AW/71/19/NMA

Application for a non-material amendment following a grant of planning permission.
Town and Country Planning Act 1990

TWO STOREY SIDE EXTENSION, FRONT PORCH AND EXTERNAL CLADDING TO FRONT ELEVATION AND RENDER (OFF WHITE) TO SIDE AND REAR ELEVATIONS. THIS APPLICATION MAY EFFECT THE CHARACTER AND APPEARANCE OF THE CRAIGWEIL HOUSE CONSERVATION AREA.

AW/85/18/HH

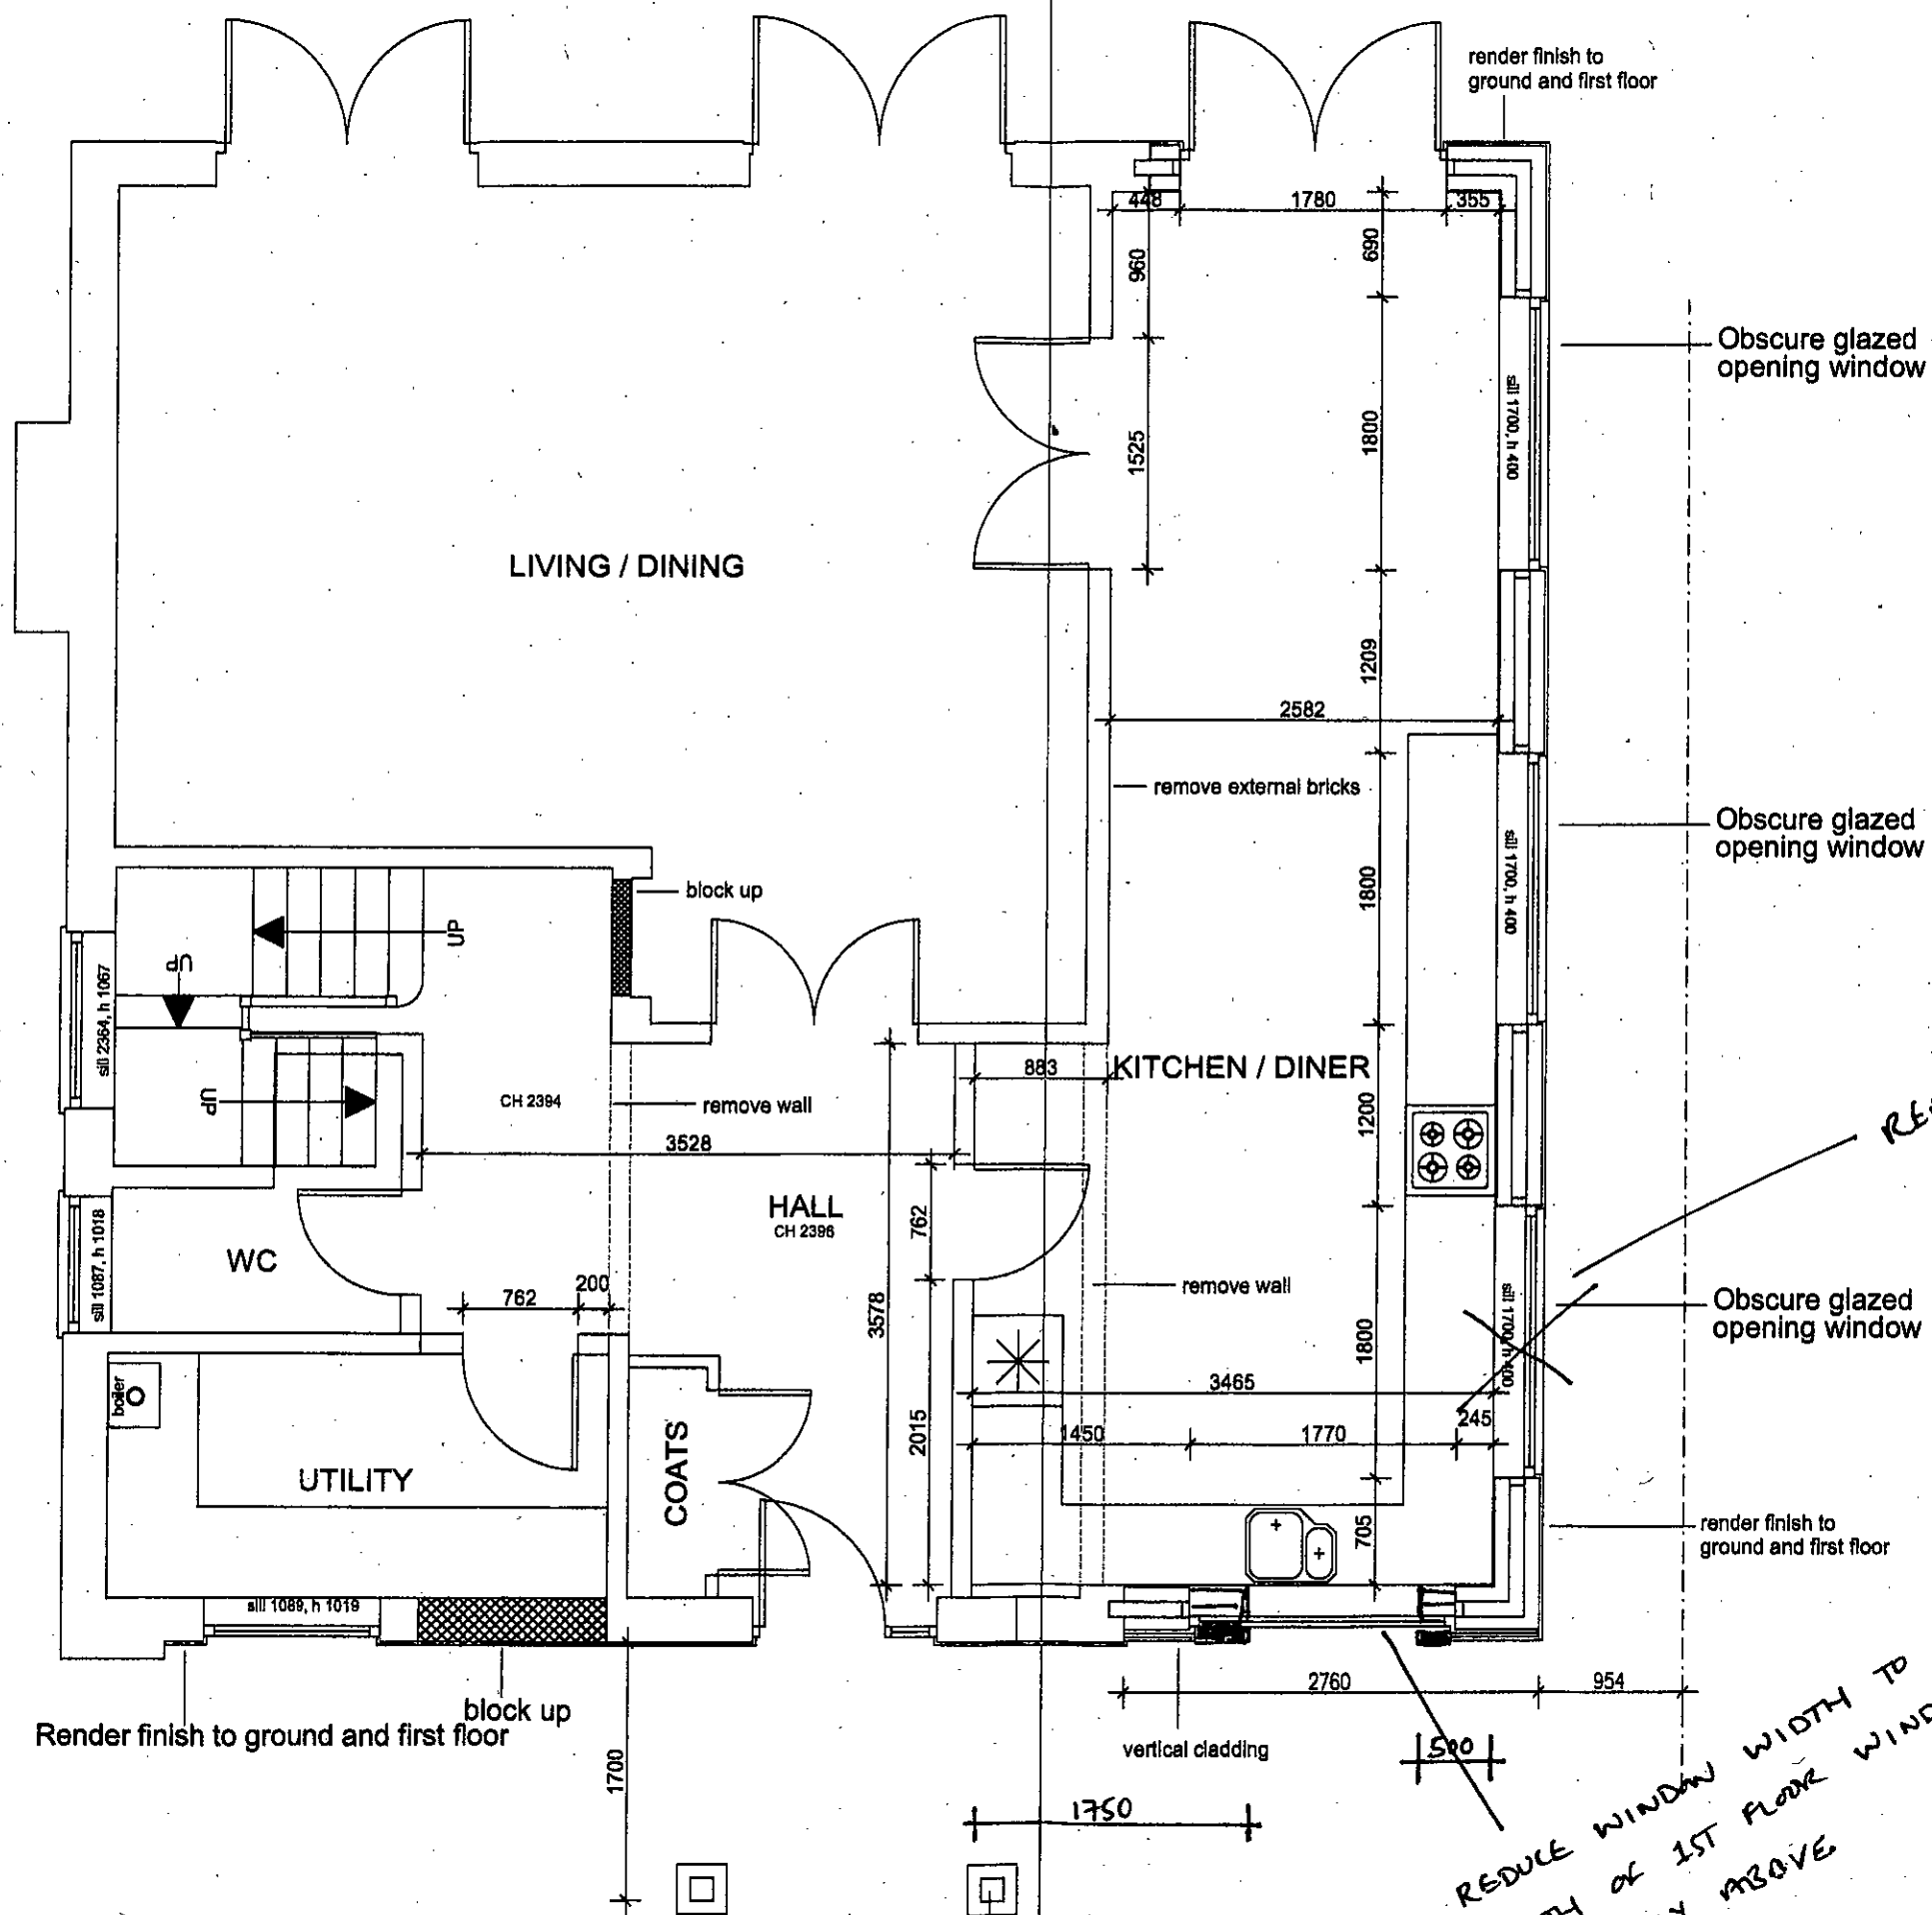
- ① I WISH TO COMPLETELY REMOVE ONE WINDOW FROM THE WEST ELEVATION OF THE EXTENSION PLAN. SPECIFICALLY THE HIGH LEVEL OBSCURED GLASS WINDOW TOWARDS THE FRONT OF THE PROPOSED EXTENSION ON THE WEST ELEVATION.
- ② I WISH TO REDUCE THE SIZE OF THE LOWER LEVEL WINDOW ON THE NORTH (FRONT) ELEVATION OF THE EXTENSION PLAN FROM 1700MM WIDTH TO A 1200MM WIDTH, WHICH WOULD THEN BE IN LINE WITH THE 1ST FLOOR WINDOW DIRECTLY ABOVE.
